From: Amber Willard
Sent: 31 May 2019 10:34
To: Planning.Responses
Subject: FW: Application Ref AW/124/19/HH - 6 Arun Way, Aldwick Bay
Attachments: 10147-DPA-02_RevA.pdf; 10147-DPA-08_RevA.pdf; 10147-DPA-07_RevA.pdf; 10147-DPA-06_RevA.pdf

From: Cara Davies [REDACTED]
Sent: 31 May 2019 10:24
To: Amber Willard
Cc: Nat Ellis
Subject: Application Ref AW/124/19/HH - 6 Arun Way, Aldwick Bay

I am writing with regard to the application at 6 Arun Way, Aldwick Bay (application ref: AW/124/19/HH).

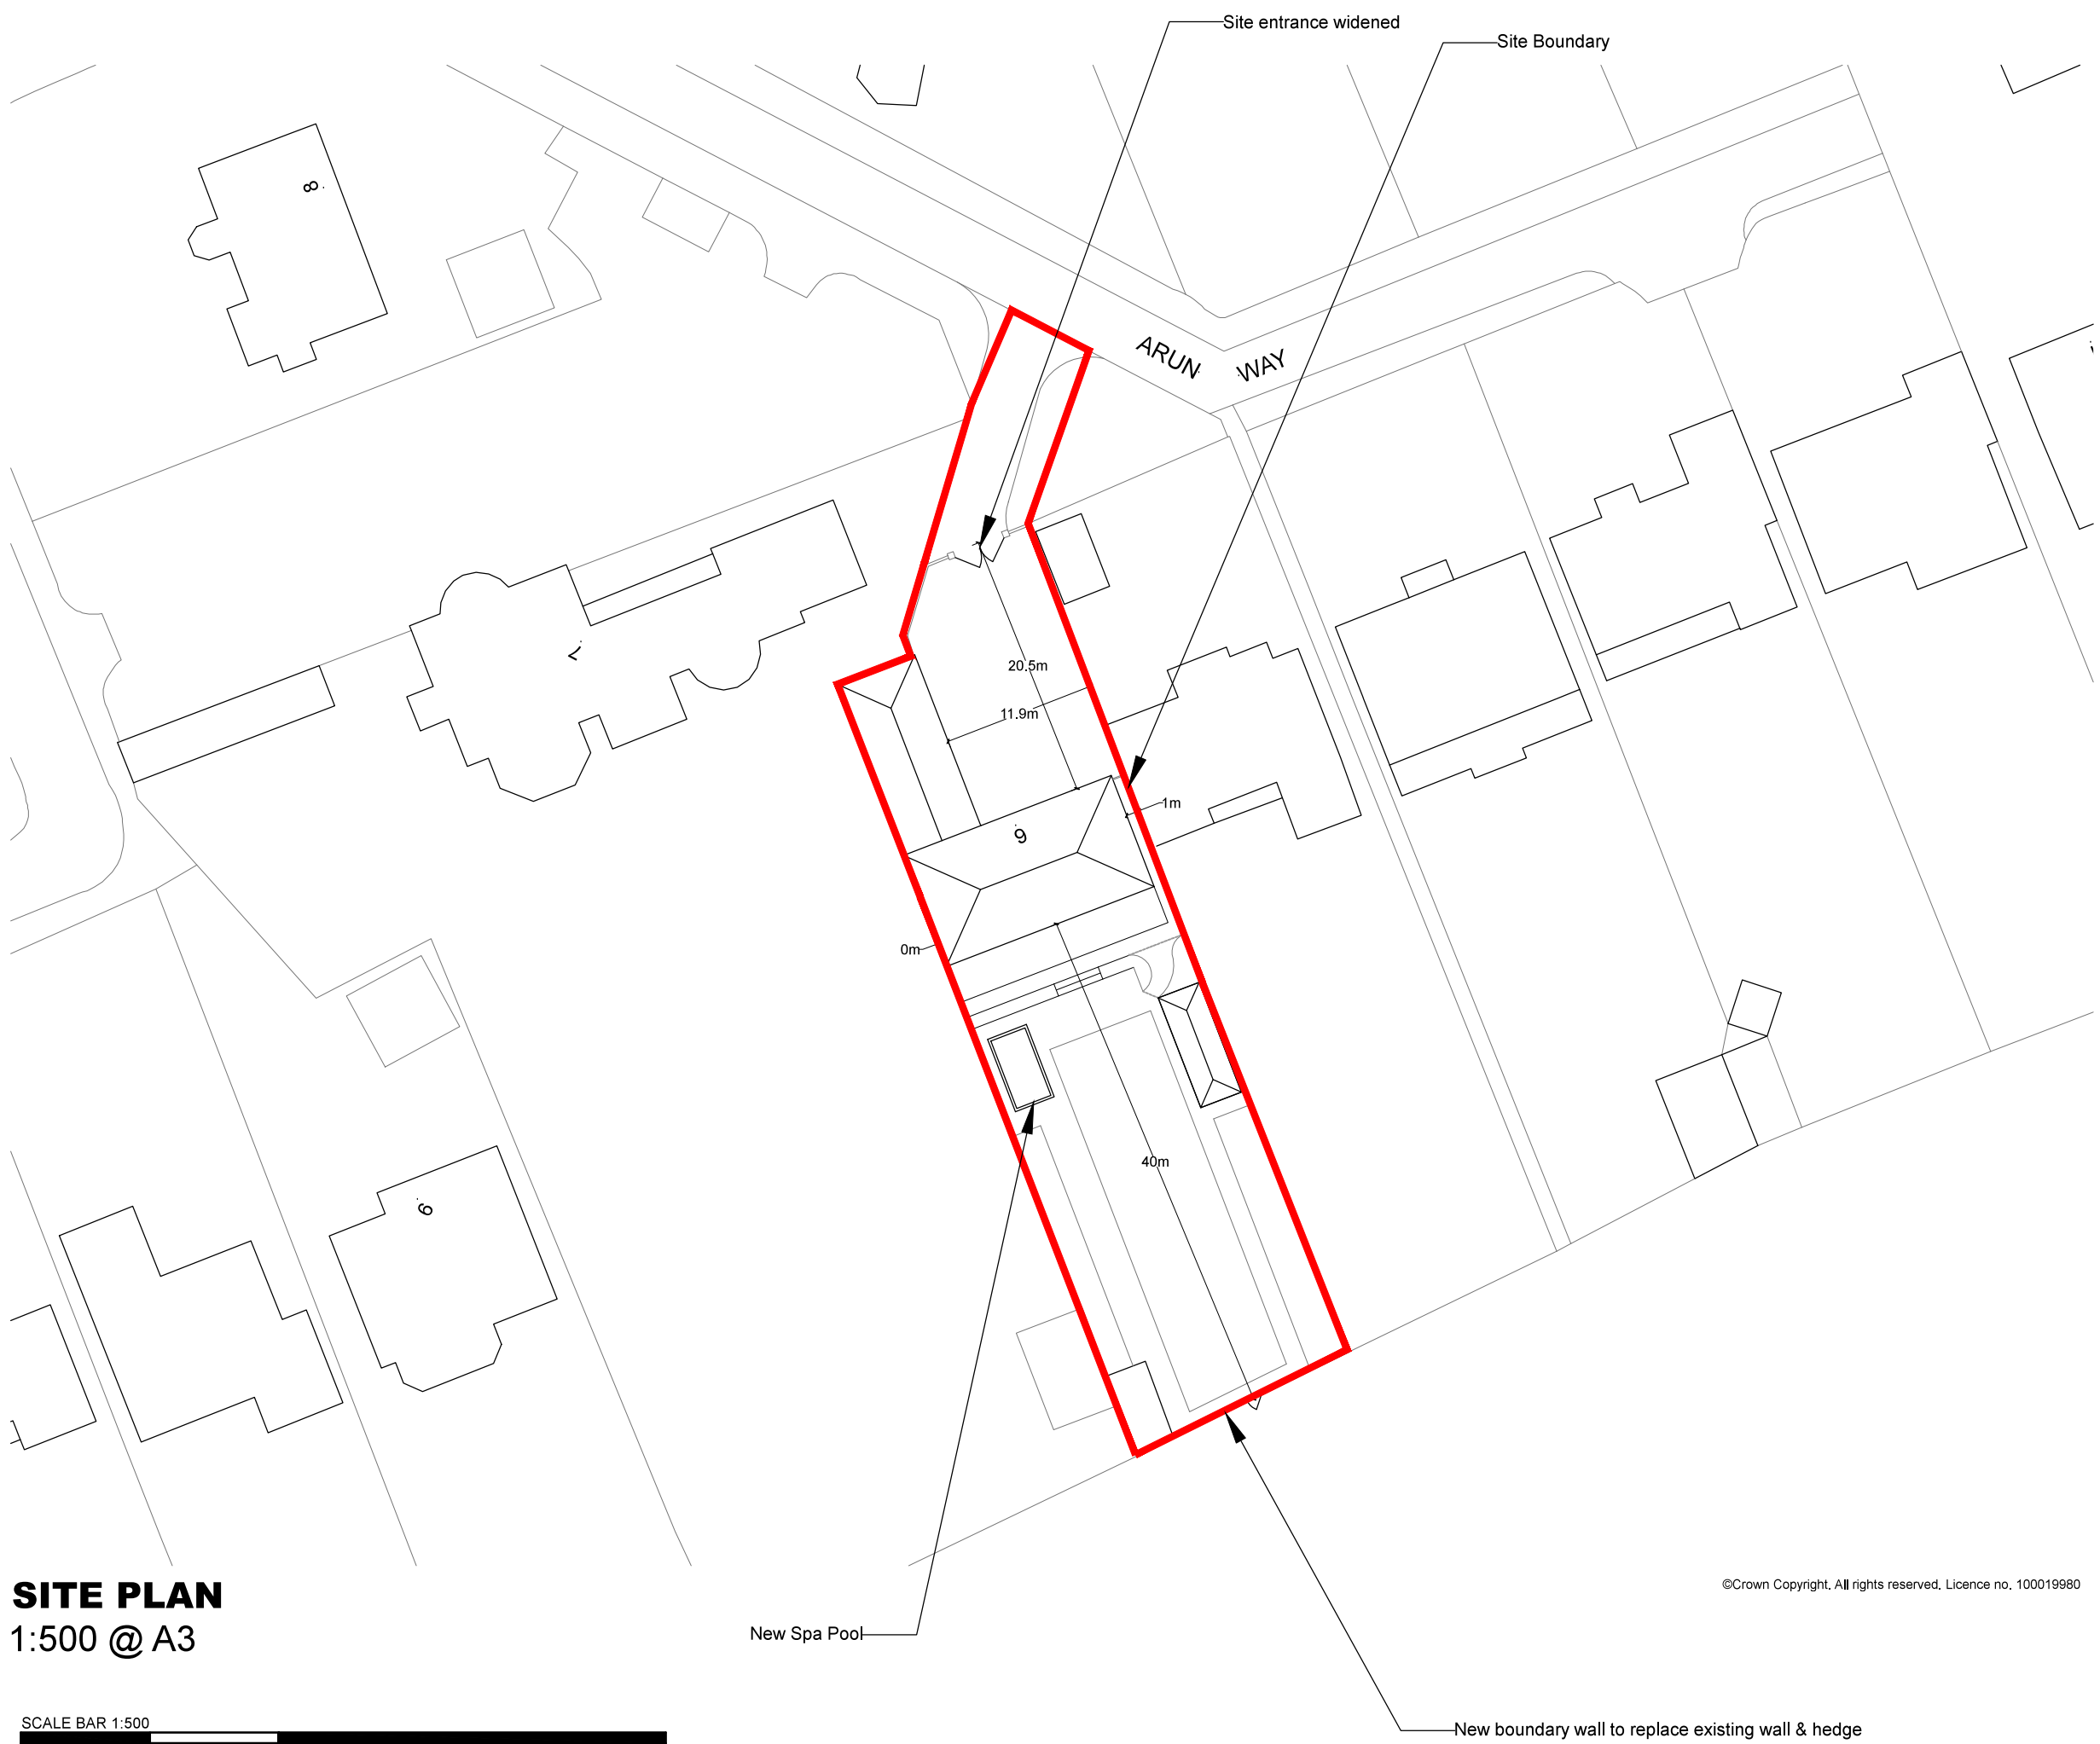
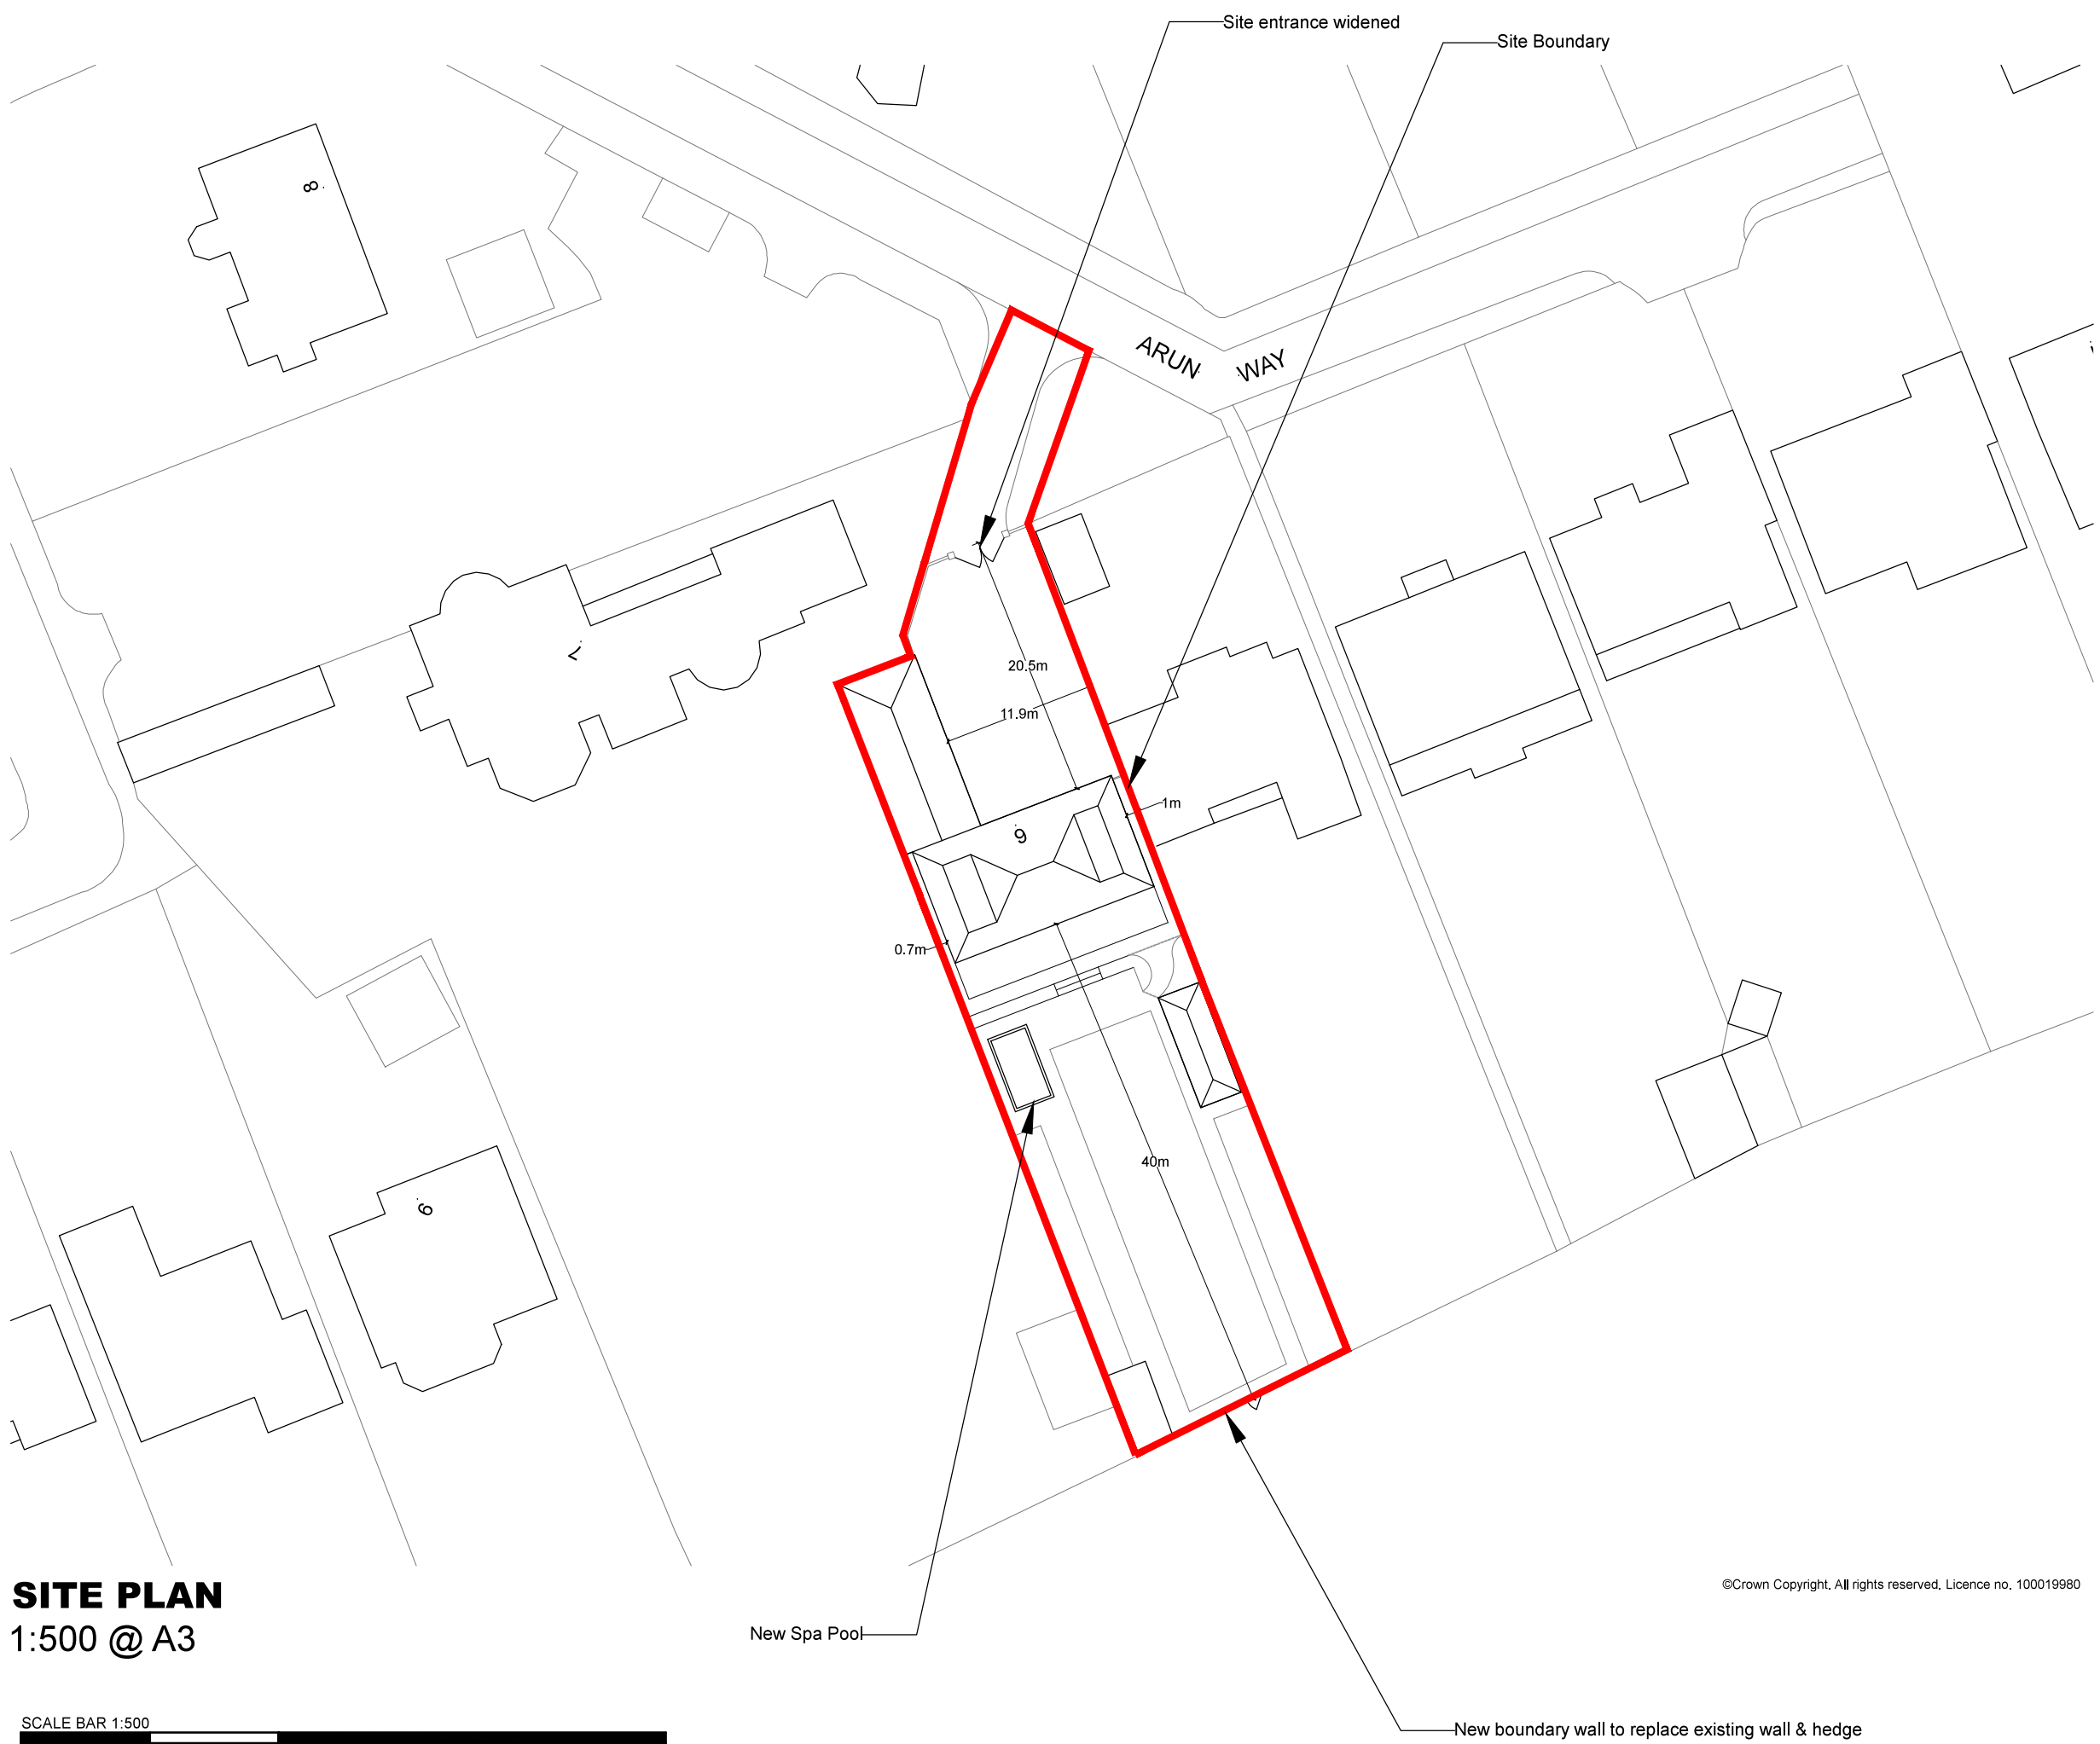
Please find attached the revised drawings which we would ask supersede the current set of plans. The changes include moving the extension approximately 750mm from the boundary, and changing the roof design to be less dominant.
